3/2021/0870

Application for a non-material amendment following a grant of planning permission.

1st Floor Extension / Raising The Roof.

1. Hip To Gable Roof. To Keep Incorporated With Neighbouring Properties.
2. Front Elevation Revised. Door & Window Positions.
3. Slate Roof Tiles To Main Roof.

MINOR MODIFICATIONS TO CURRENTLY APPROVED

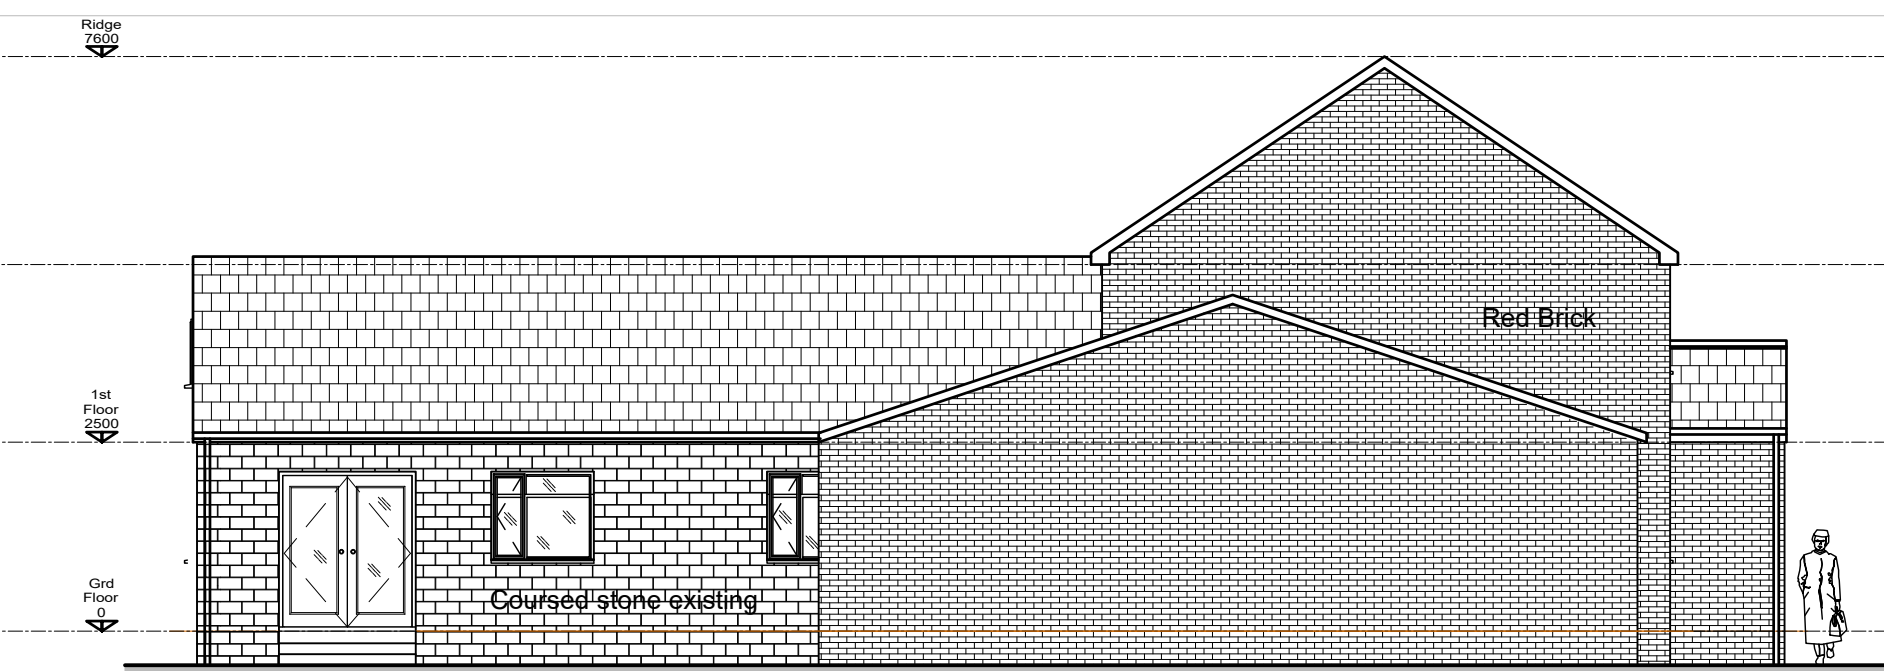
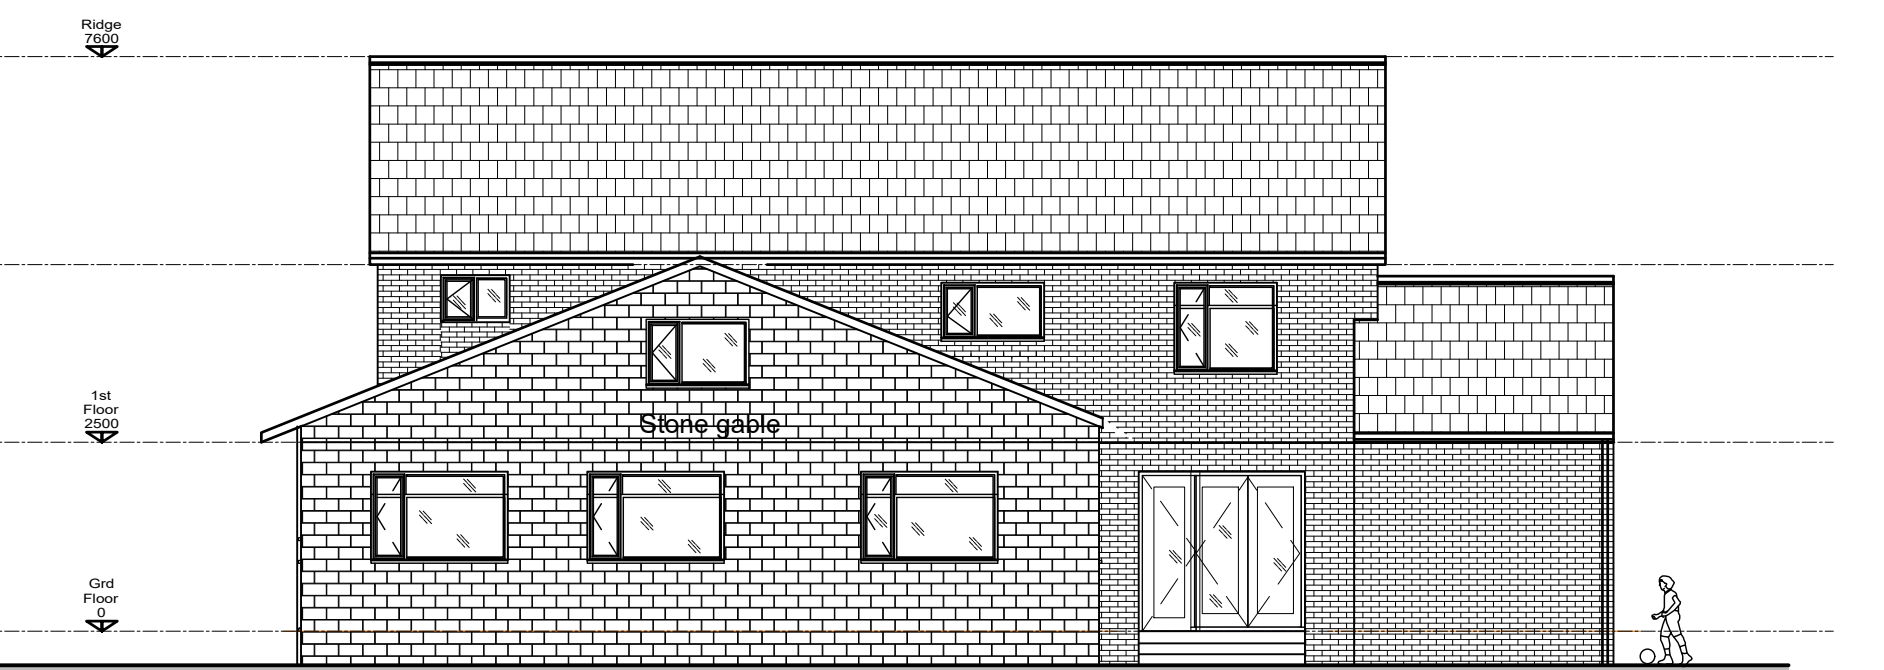
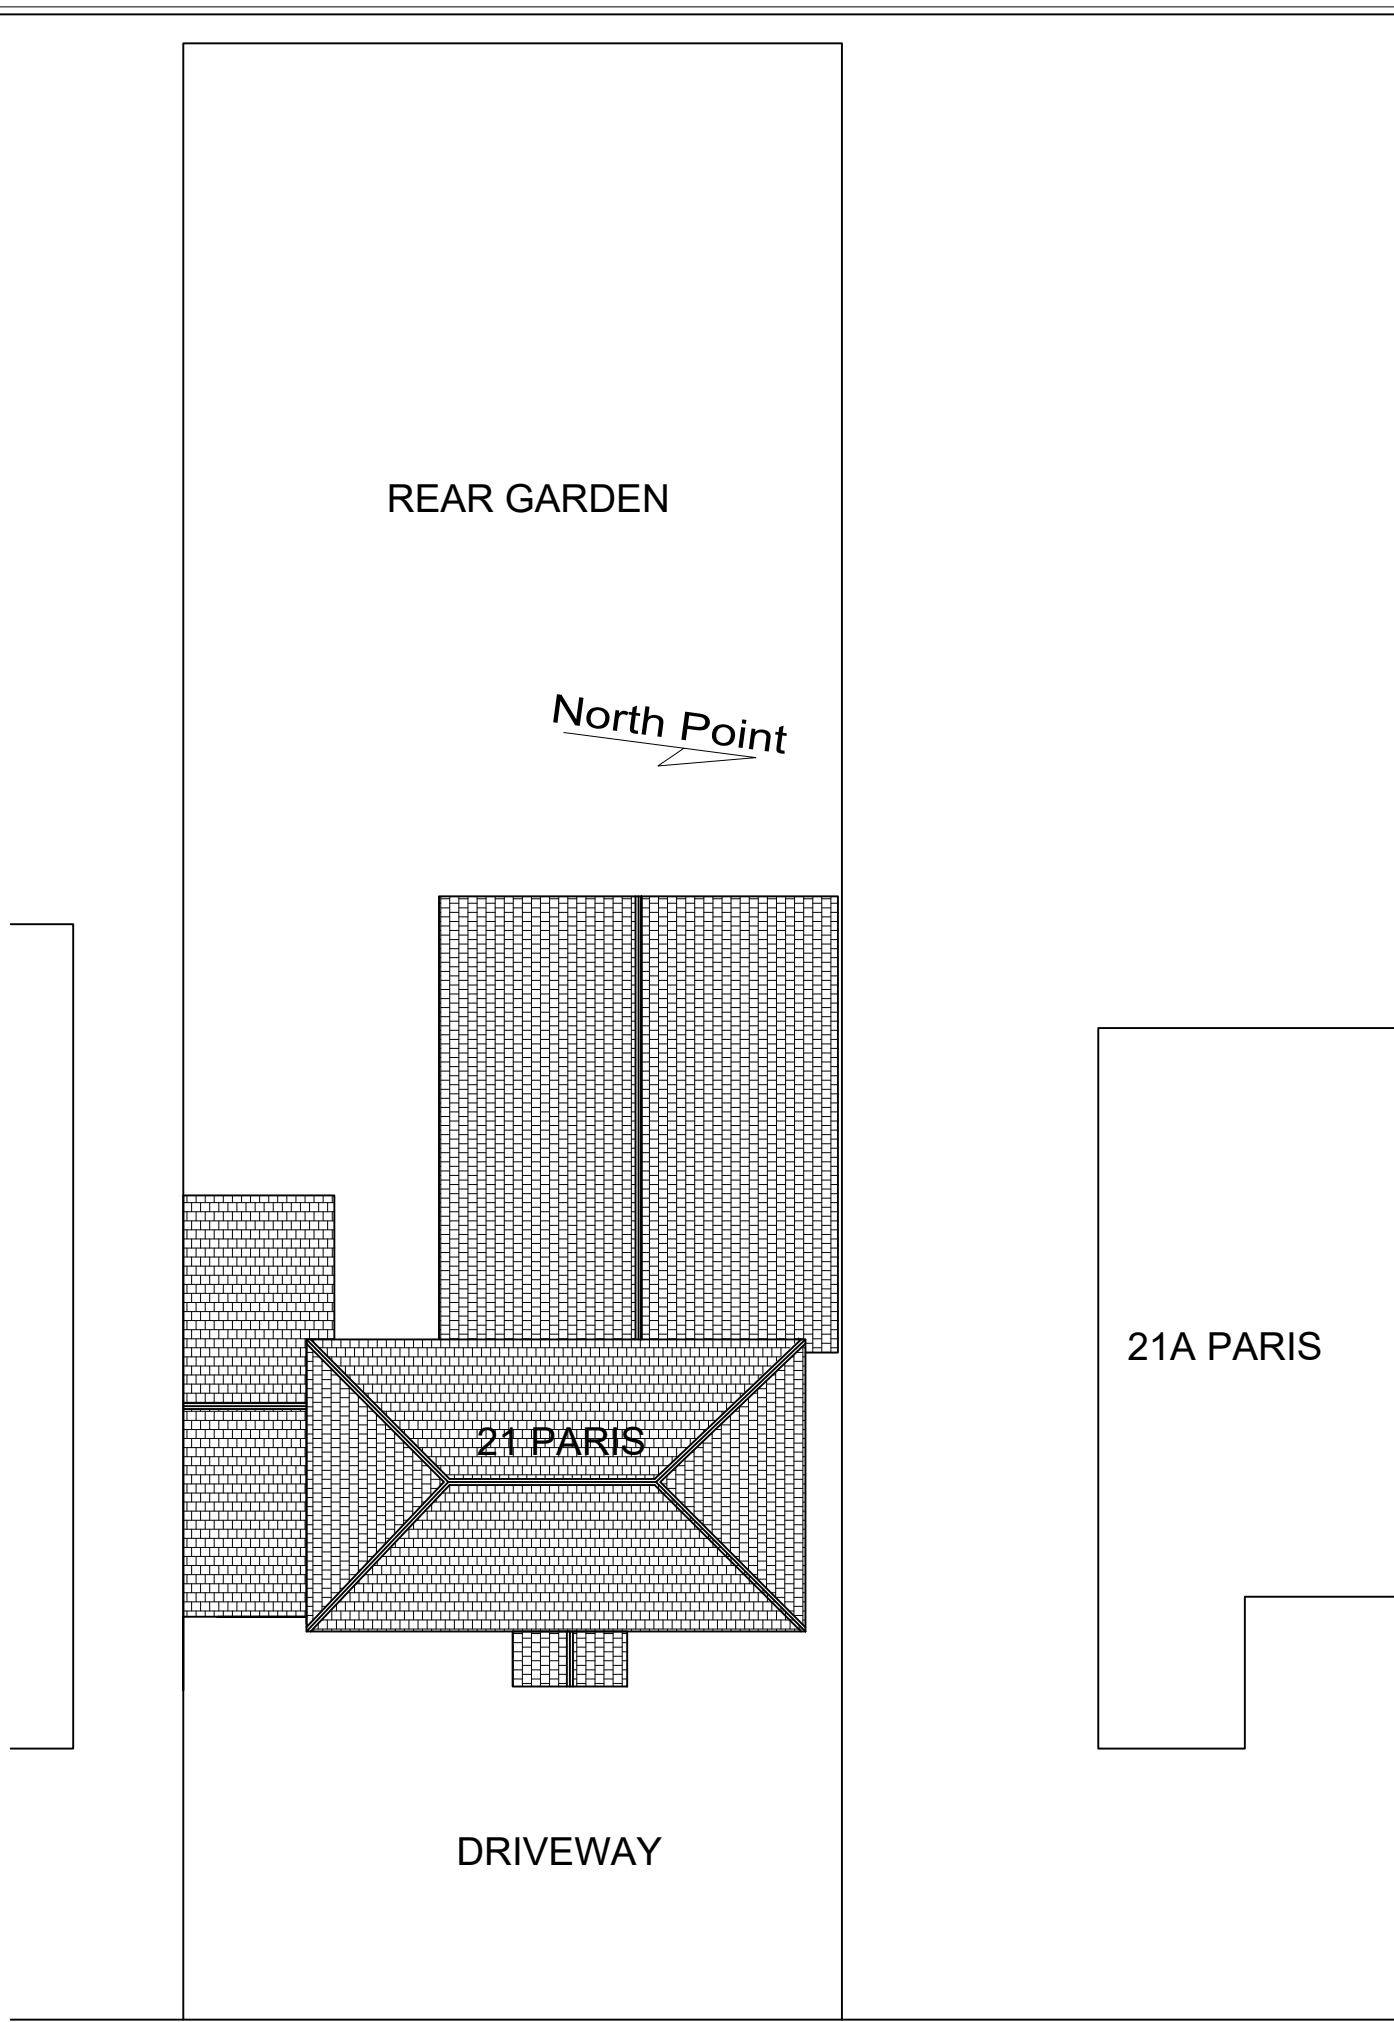
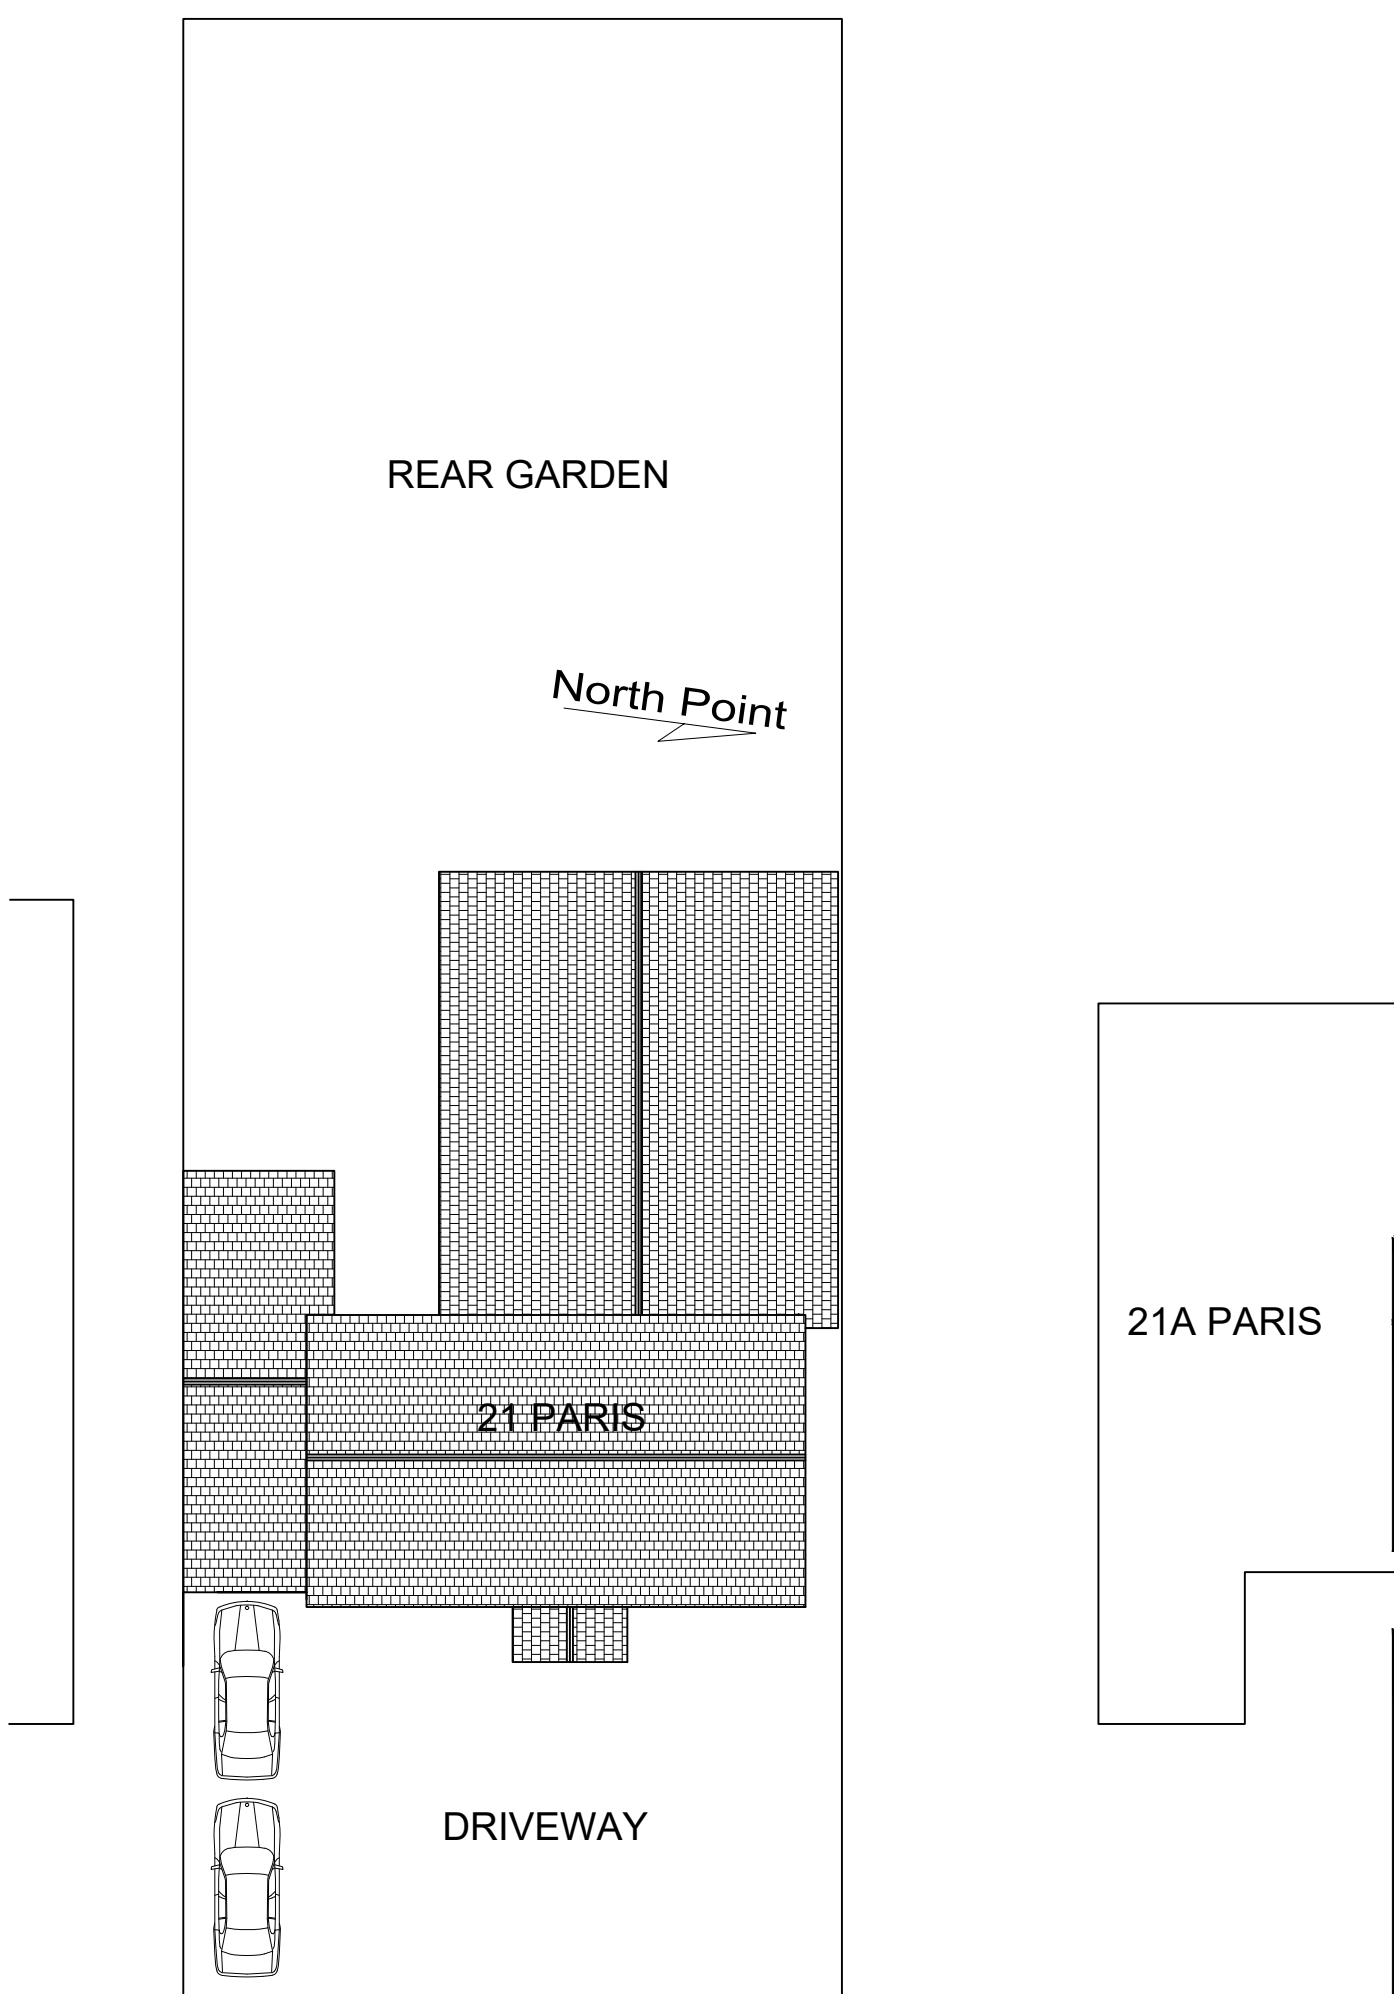
TO KEEP THE HOUSE IN BALANCE WITH THE NEIGHBOURING PROPERTIES. ALL EXISTING HOUSES HAVE GABLE ROOF / SLATE FINISH OVER. PROVIDE A BETTER FRONT ELEVATION.
